WALBERTON PARISH COUNCIL

Planning Application WA/21/14/PL – Turnpike Motors, The Street, Walberton
Demolition of garage and workshops, and erection of 6 no 3 bed dwellings.

Rev A Roof lights shown on first floor plan and roof plan			April 2014
REVISION			
PROJECT		Proposed development at Turnpike Motors, The Street, Walberton	
SUBJECT		Proposed Cottage Floor Plans and Elevations	
SCALE 1:100 @ A2	DATE April 2014	DRAWING No 02 / 62 / 08	Rev A
DRAWN	CHECKED

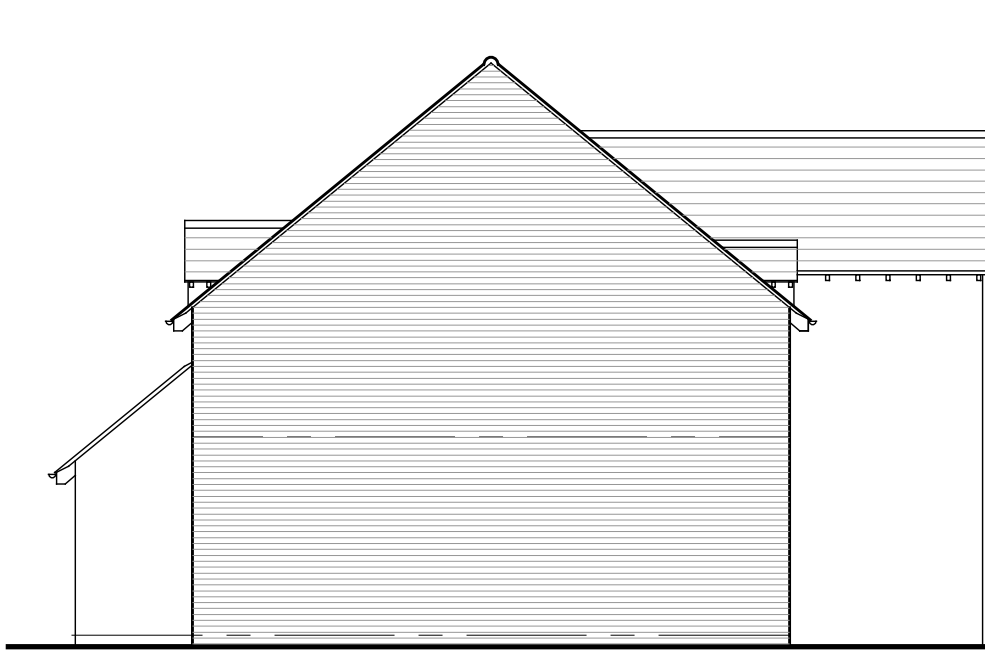
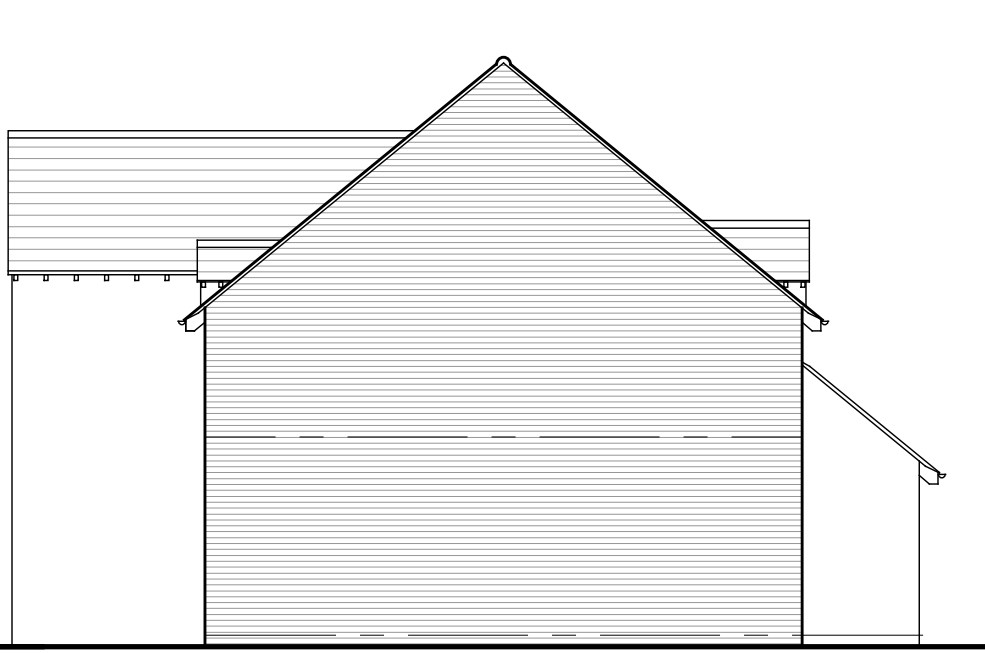
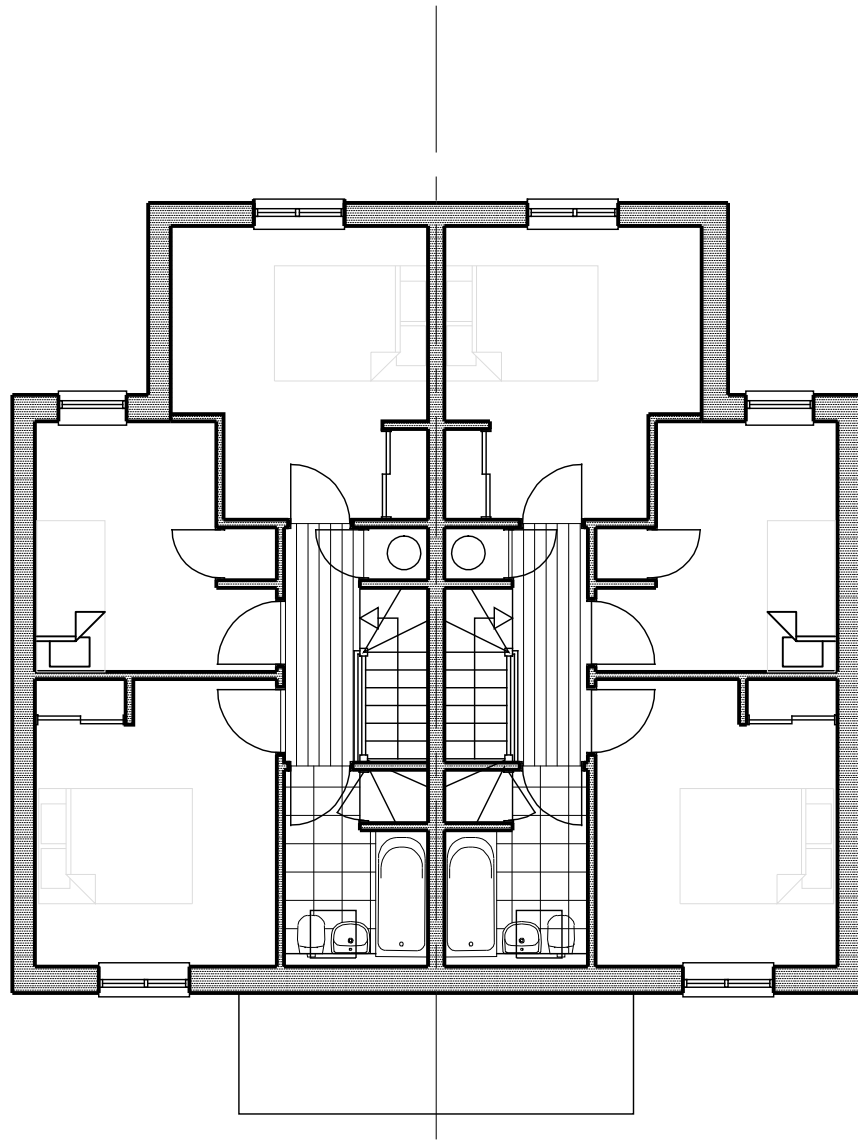
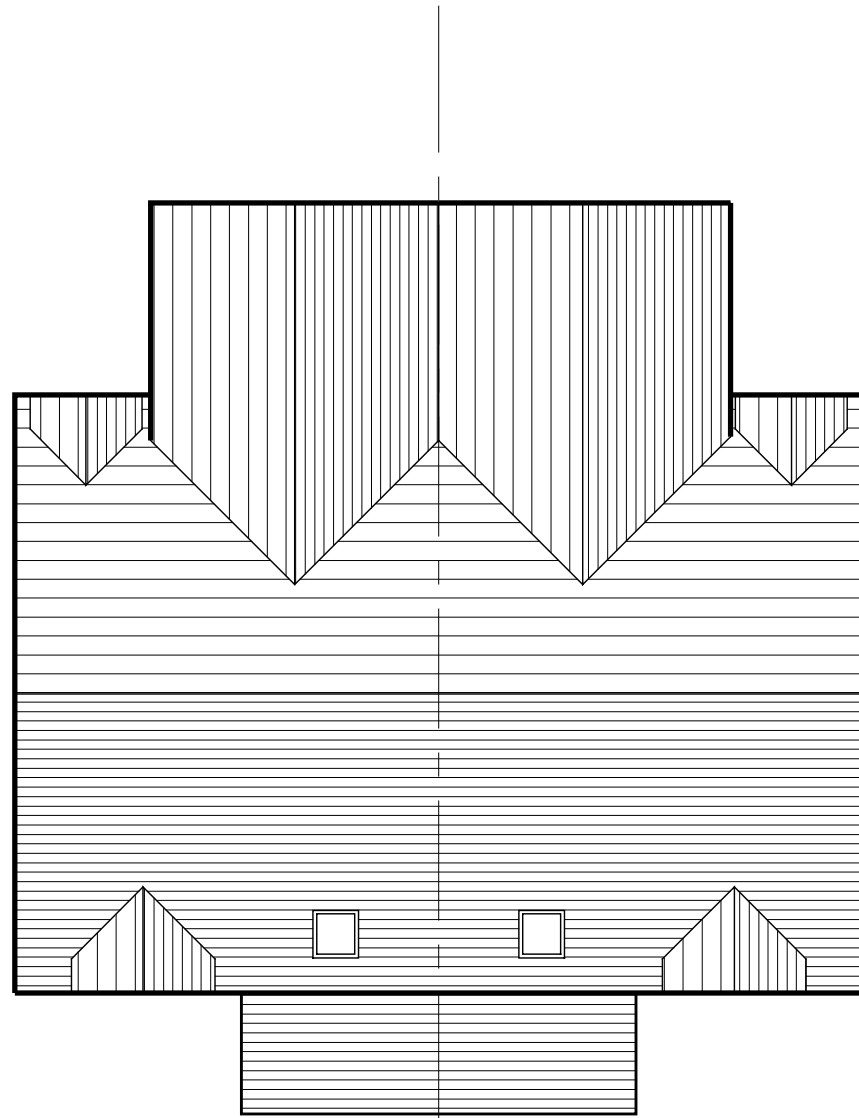
This Council has carefully considered the above application above and does not wish to object, but would like a condition imposed requiring the use of conservation style roof lights and appropriately styled flint work, brick work, dormers and window/door joinery. This is because the proposed development falls within the conservation area and will form a very visible part of the street scene.
